An Coimisiún Pleanála – Tirawley Wind Form Case Reference:PAX16.324258

Observation

Observation Objecting to An Coimisiún Pleanála - Case Number: PAX16.324258

Re: Planning permission for the construction of Tirawley Windfarm consisting of 16 wind turbines, a permanent 110kV substation, 110kV underground cable and grid connection, and ancillary developments. I am writing to formally oppose the proposed Tirawley Windfarm development on the grounds set out in this document.

Figure 12.1 ZTV (Zone of Theoretical Visibility) indicating the areas that have a potential view of the proposed turbines at Tirawley Wind Farm (135m Tip Height)

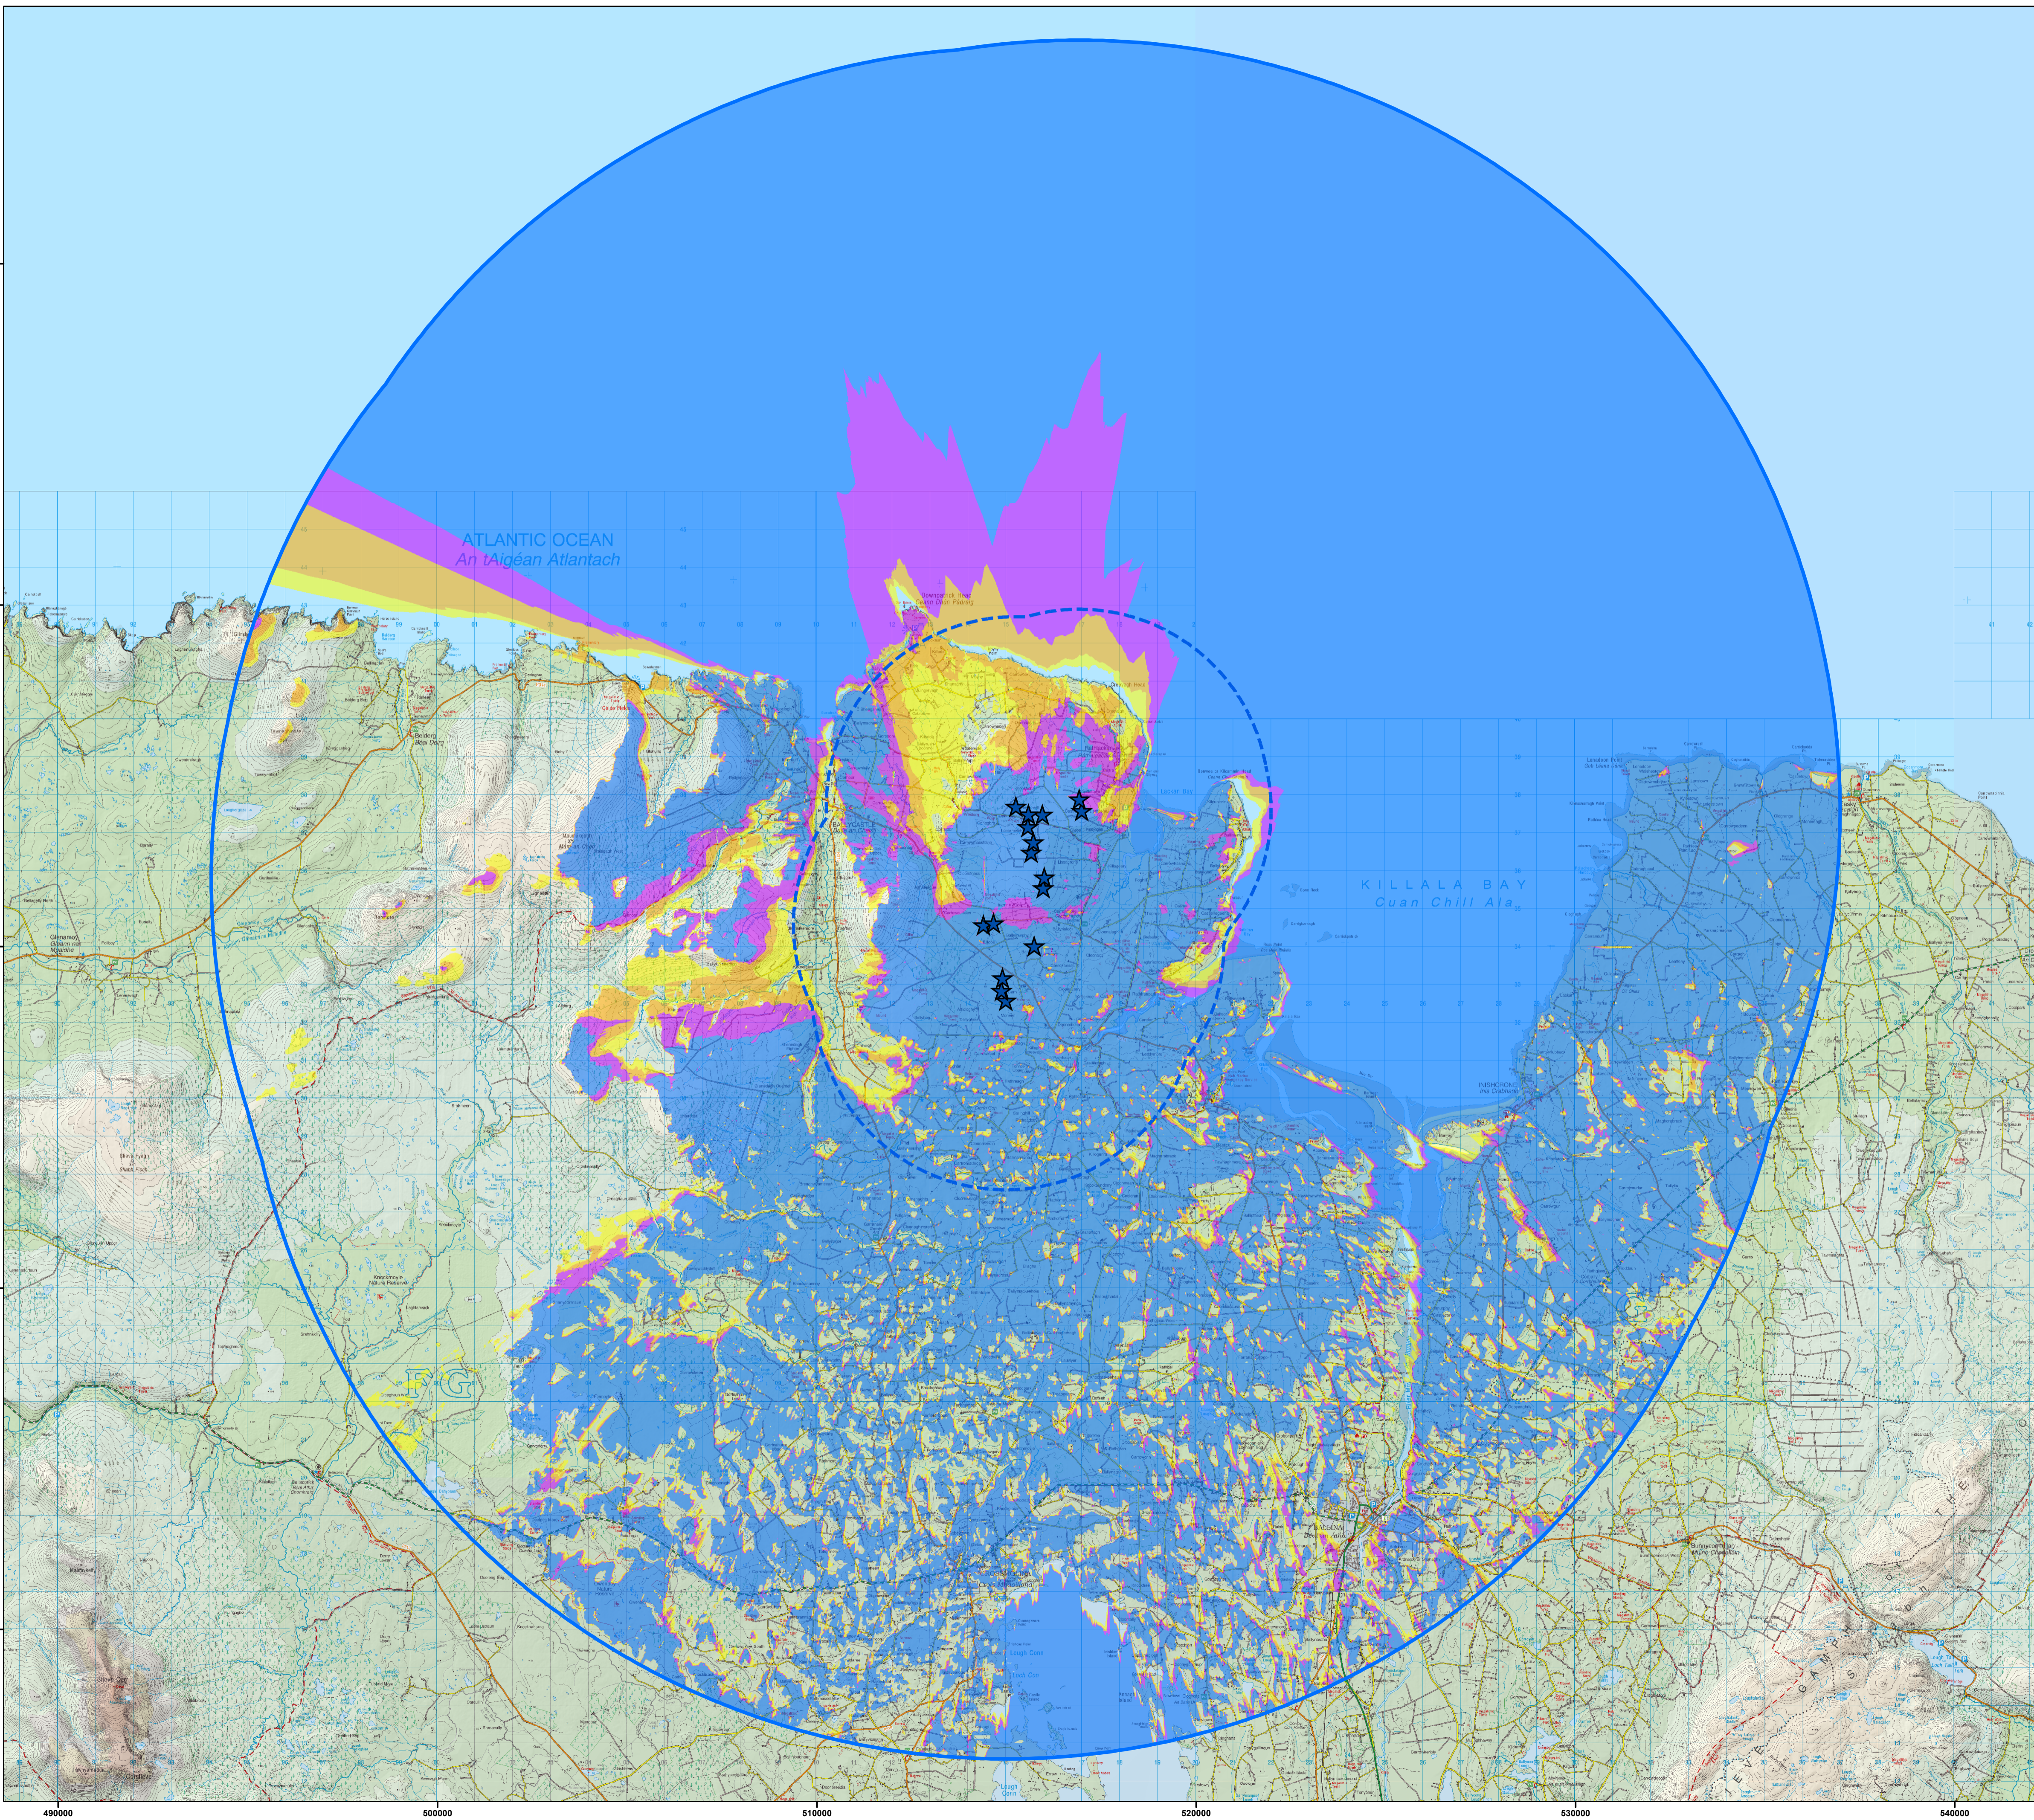
The Zone of Theoretical Visibility (ZTV) maps as shown in Map 1,2,3,4 demonstrate visibility extending far beyond the application site. Total inadequacy is evident in the consideration of the red lines around turbines and how it ignores the wider zones of influence critical to satisfying national and European environmental legislation.

The visual map of the Zone of Theoretical Visibility (ZTV) indicates areas that have a potential view of the proposed turbines at Tirawley Wind Farm (135 Tip Height) at 5 kilometres and 29 Kilometres speaks shows the degree of visibility. (See Map 1,2,3,4)

Consideration of a 40-kilometre ZTV has not been considered and this is a requirement. The turbines will be seen right down to Lough Conn, Nephin and I would argue that the social, economic and environmental reverberations are equally present.

Figure 6.2: Vantage Point (VP) locations and viewshed map.

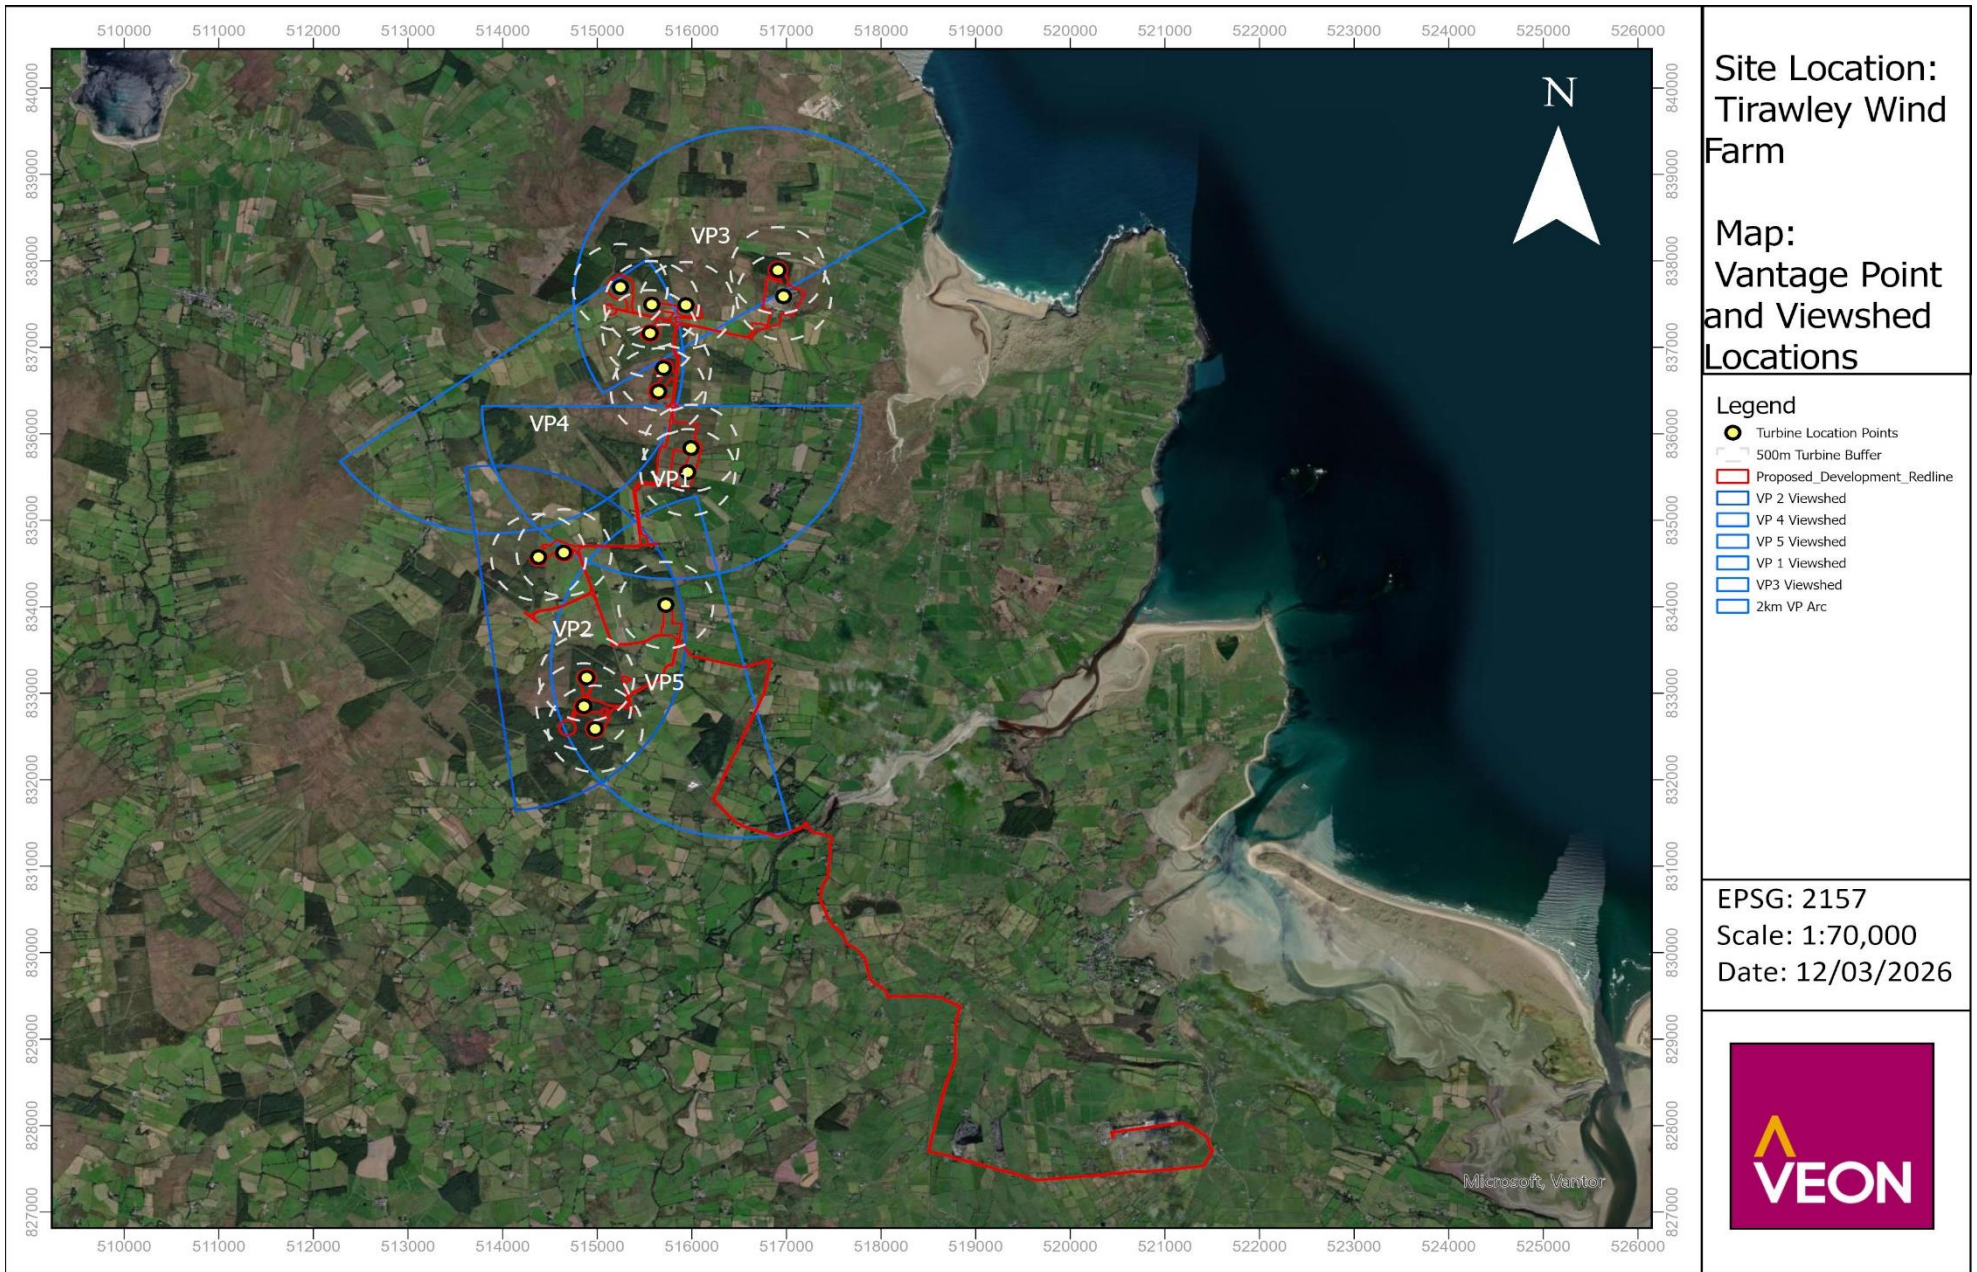
Map 11 below of the Vantage Point Viewsheds show that Vantage Point 1 (VP1) omits a significant part of North Lissadrone and also a significant part of Killogeary where the Lacken Saltmarsh and Kilcummin Head SAC is located. VP3 transect tracks bird movement to the North of the Castlelacken Demesne, Keeloges and most of the Glebe where the wind turbine is located in a quarry. The quarry itself is not even covered by any VP1 or VP2 examination of bird flight. This is not a very comprehensive survey and leaves many questions unanswered and it is important to proceed with caution in any full assessment of the zone of proximity to the wind farm.
